CLAREMONT RANCH FILING NO. 9C

REPLAT OF LOTS 1-4, CLAREMONT RANCH FILING NO. 9B
IN THE NORTHWEST QUARTER OF SECTION 4, T14S, R66W OF THE 6TH P.M.
COUNTY OF EL PASO, STATE OF COLORADO

VR-18-011

AS PLATTED

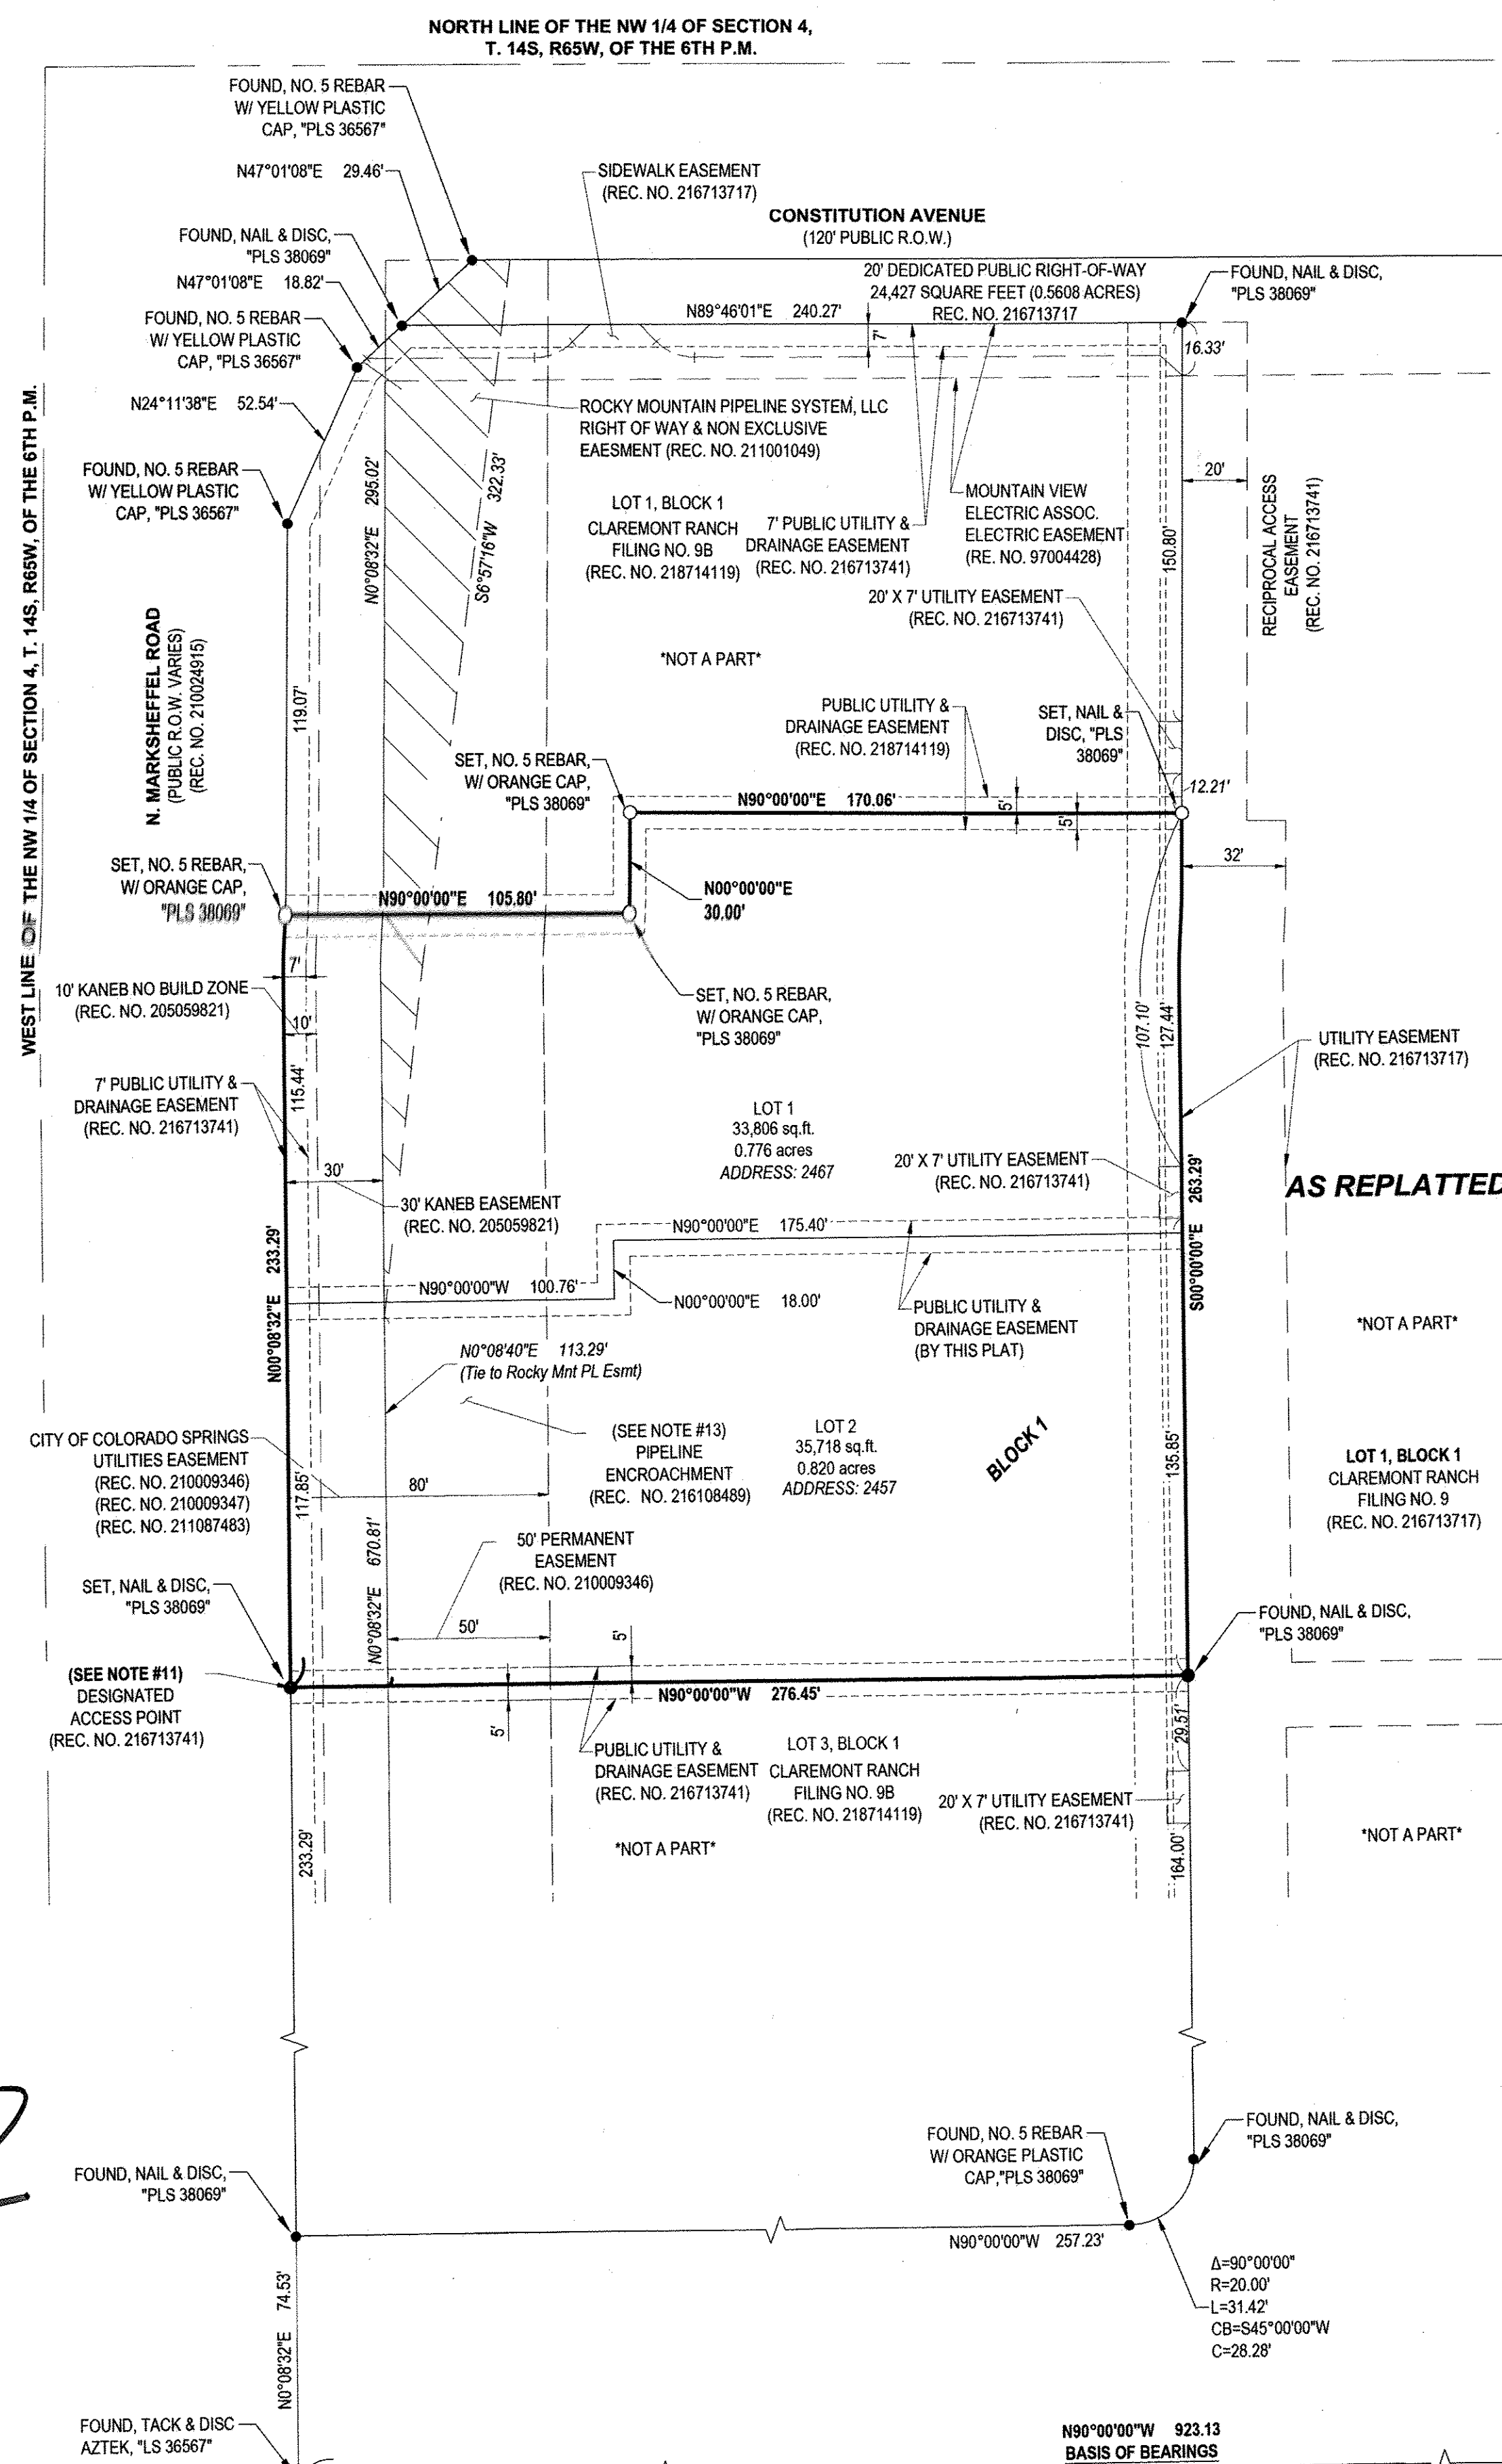
Per Section 7.2.5(C)(3)(d) when replatting an entire subdivision the lots shall be numbered consecutively starting with the number "1", this subdivision should be listed as 1 & 2, not 2A and 2B

A vacate replat is generally for the the lots specific to the request, only a cropped section of Lot 2 needs to be shown on "As platted" and on as replatted — with the correct numbering of lots. The remaining lots can keep original numbers. The new lots will be Lots 1 & 2 of Filing 9C
